# ETHOS URBAN

## Response to Public Individual Submissions

Redevelopment of Greenwich Hospital

27 September 2019 | 2190376

DRAWING TITLE: EXISTING TREES		DATE: AUGUST 2019		DRAWN: EC		PROJ ARCH: BF		SCALE: 1: 500 @ A1	
				PROJ: 1213		DRAWING: S.10		REVISION: P5

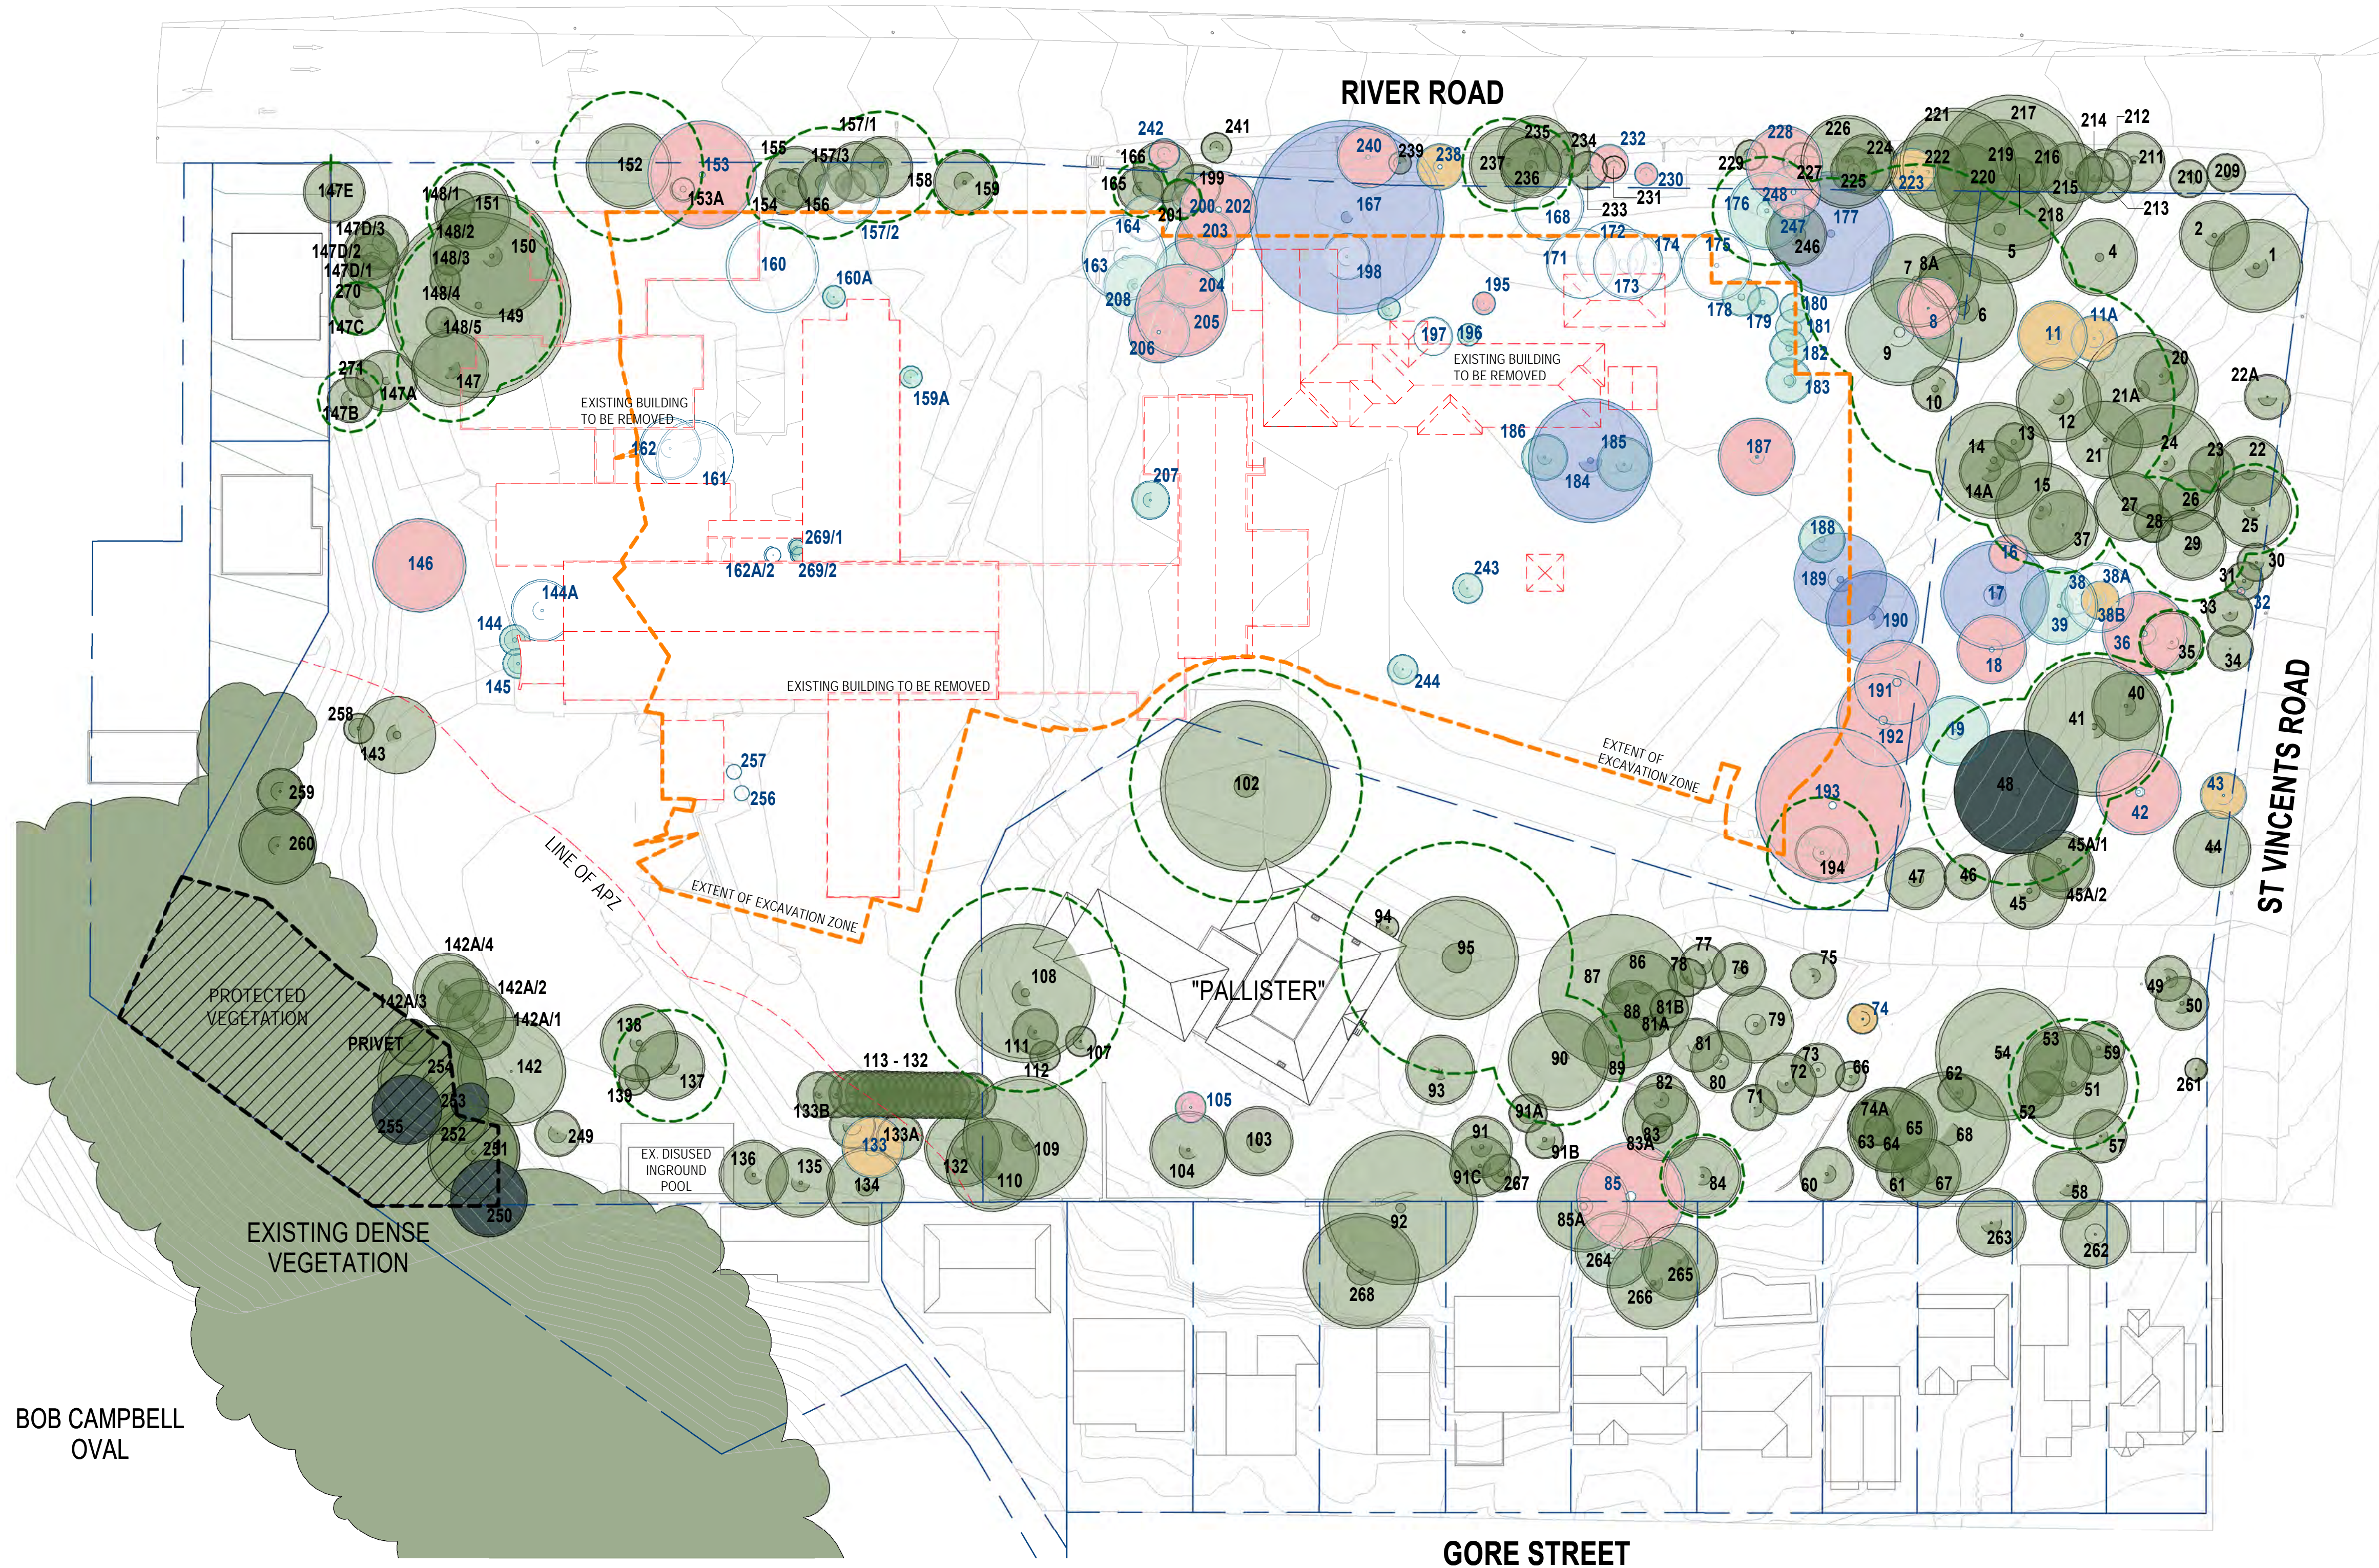
Summary of Issue	Response	No. of times raised
<b>Environment</b>		
Tree and bushland removal (general)	The amended proposal has been designed to maximise the retention of existing significant vegetation and provide new planting to increase the existing tree canopy. In particular, a revised Arborist Report has been prepared by Redgum Horticultural and is available at <b>Appendix F</b> , confirming that under the revised scheme, tree retention and planting on the site is to exceed tree removal. This issue is further addressed at <b>Section 2.7</b> of the RTS report.	104
Impact on flora and fauna / biodiversity impacts	As above, the revised scheme aims to maximise vegetative retention and will also include the planting of 60 new trees, thereby improving the tree canopy cover overall. This includes retaining all vegetation to the southwestern corner of the site (where no significant works are proposed) adjacent to the Gore Creek Bushland Reserve, to minimise impacts on flora and fauna as a result of the proposed redevelopment of the site. This issue is further addressed at <b>Section 2.7</b> of the RTS report.	42

Loss of vegetation buffer to surrounding residential properties	The revised scheme aims to minimise vegetation loss, including with regards to the vegetation buffer between the site and surrounding residential properties. As the Amended Architectural Plans provided by Bickerton Masters at <b>Appendix A</b> demonstrates, generally all development maintains existing setbacks to boundaries (with the exception of the respite care facility and some works along River Road) which allows all trees between the existing access road and residential properties along Gore Street to the south of the site to be kept. Furthermore, existing vegetation between the proposed seniors living facilities and residential properties to the west of the site will predominantly be kept, to provide suitable screening to those properties.	6
